Our ref: RA/2025/148983/01-L01
Your ref: 2025/92882
Date: 02 December 2025

**ERECTION OF 75 DWELLINGS WITH ASSOCIATED PARKING,
INFRASTRUCTURE, HARD AND SOFT LANDSCAPING AND ACCESS FROM
MANCHESTER ROAD
CELLARS CLOUGH MILL, MANCHESTER ROAD, MARSDEN, HUDDERSFIELD,
HD7 6LY**

In the absence of an adequate flood risk assessment (FRA) we object to this application and recommend that planning permission is refused.

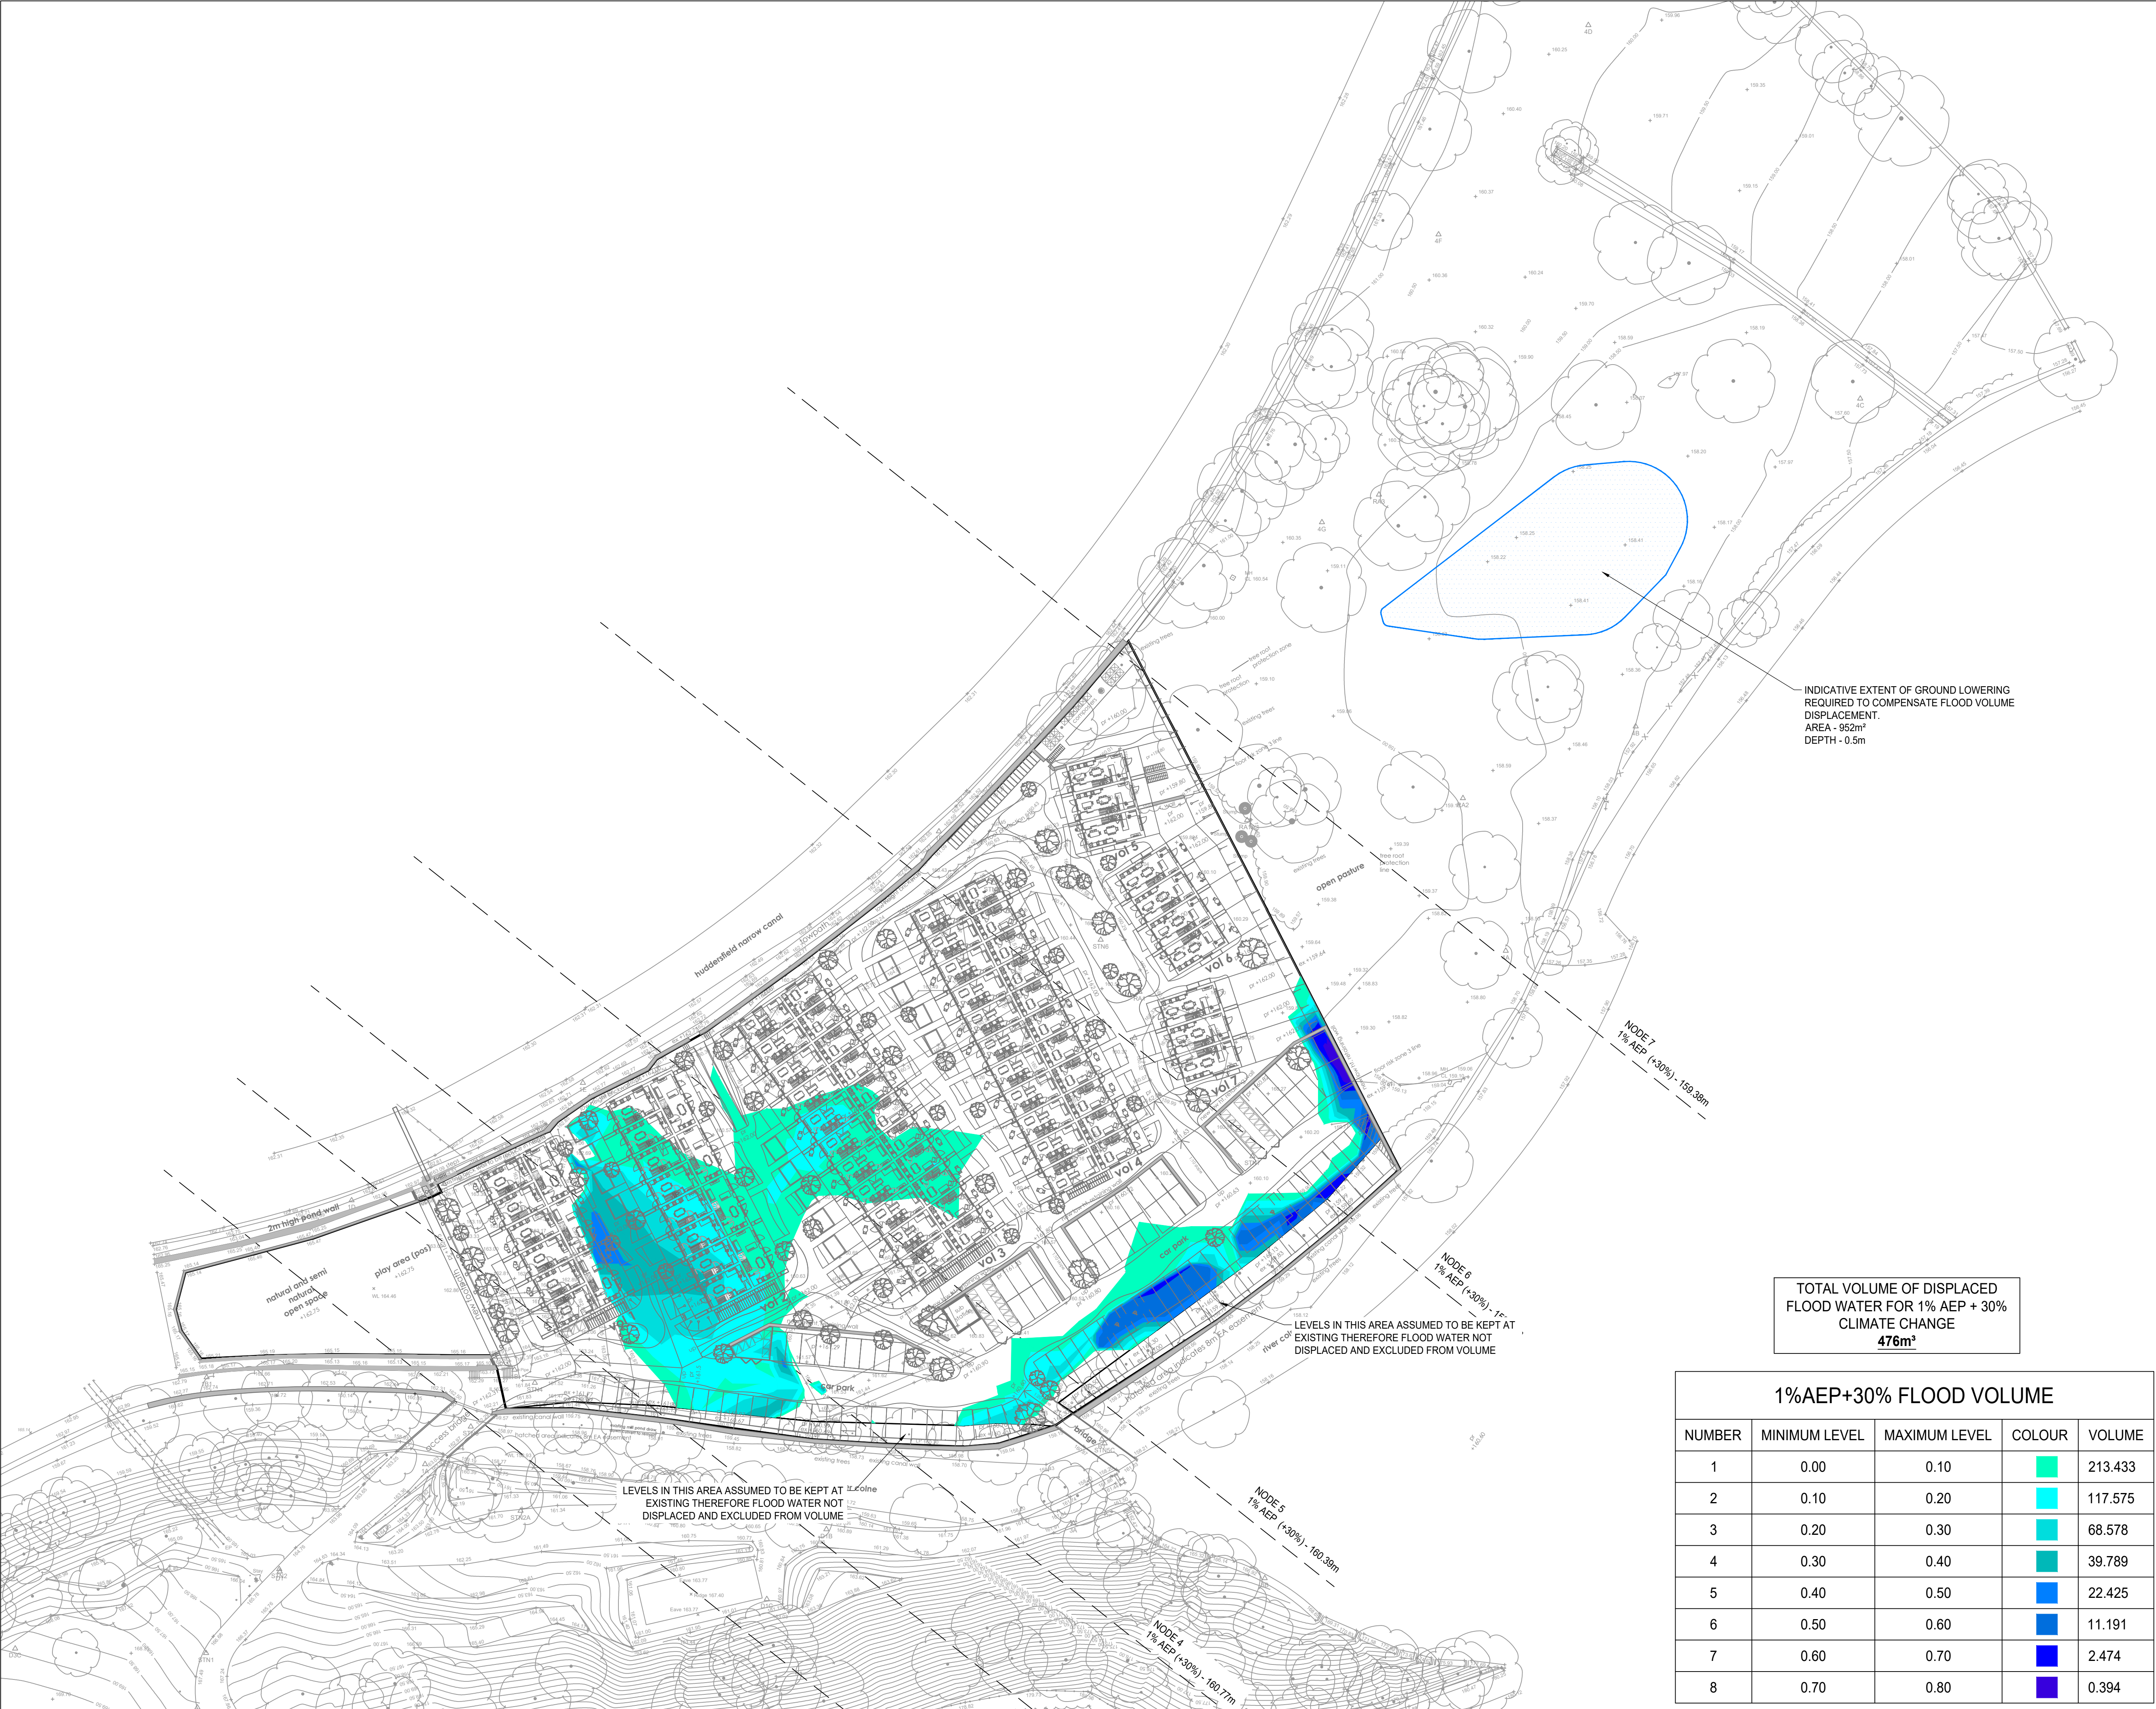
We understand from the FRA that the whole site will be raised above the design flood level. It is unclear how the compensatory storage requirements have been calculated. The FRA should be updated to demonstrate how hydraulically linked like for like level for level flood compensatory storage outside of the design flood event flood extent shall be achieved.

The FRA currently only provides an indication where the compensatory storage might be located but does not provide any further details. Please note, the current location for the proposed compensatory storage is within the design flood event flood extent and is therefore not considered suitable.

To overcome our objection, the applicant should submit a revised FRA which addresses the points highlighted above.
